**WEST SUSSEX COUNTY COUNCIL
STRATEGIC PLANNING CONSULTATION**

DATE: 17th June 2014

**SUBJECT: AL/26/14/PL - Change of use from 5 no. tourist units to 5No. residential units
(C3 Dwelling).**

**Easter Cottage, Norton Dairy, Cart Barn East Barn, Old Dairy Lane/Norton
Lane, Aldingbourne, West Sussex, PO20 3AF**

SITE PLAN 1:200

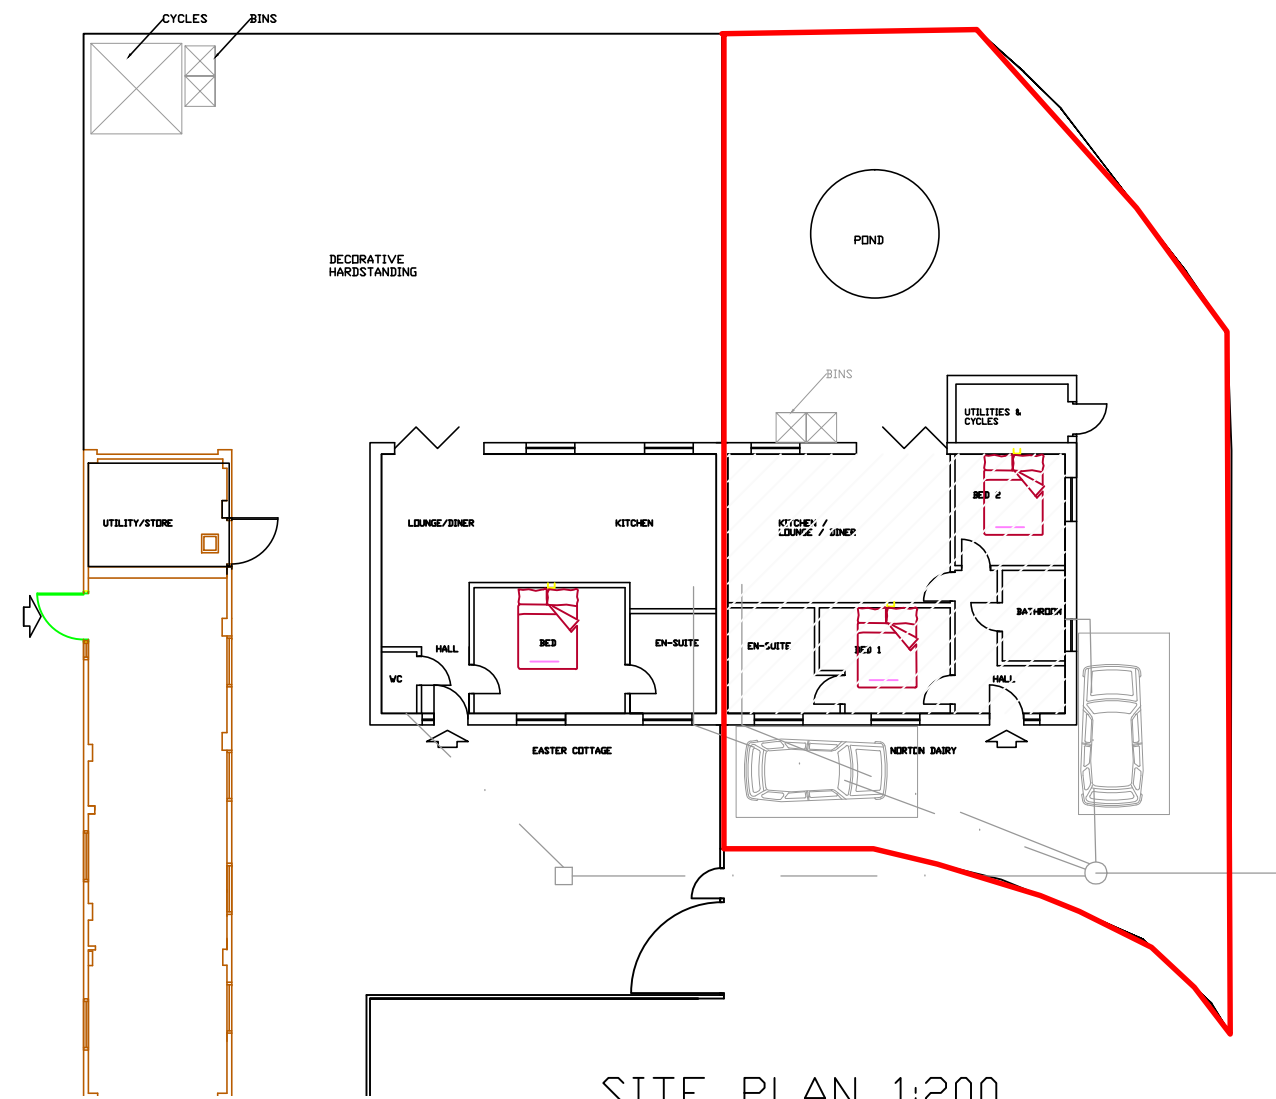
- 3) WSCC would still like a full car parking plan showing the layout of all the car parking spaces. It was never thought car parking for this number could not be achieved but as this will become a permanent residential area, as with any new developments we require a parking strategy. We look forward to receiving this including the visitor spaces as recommended.
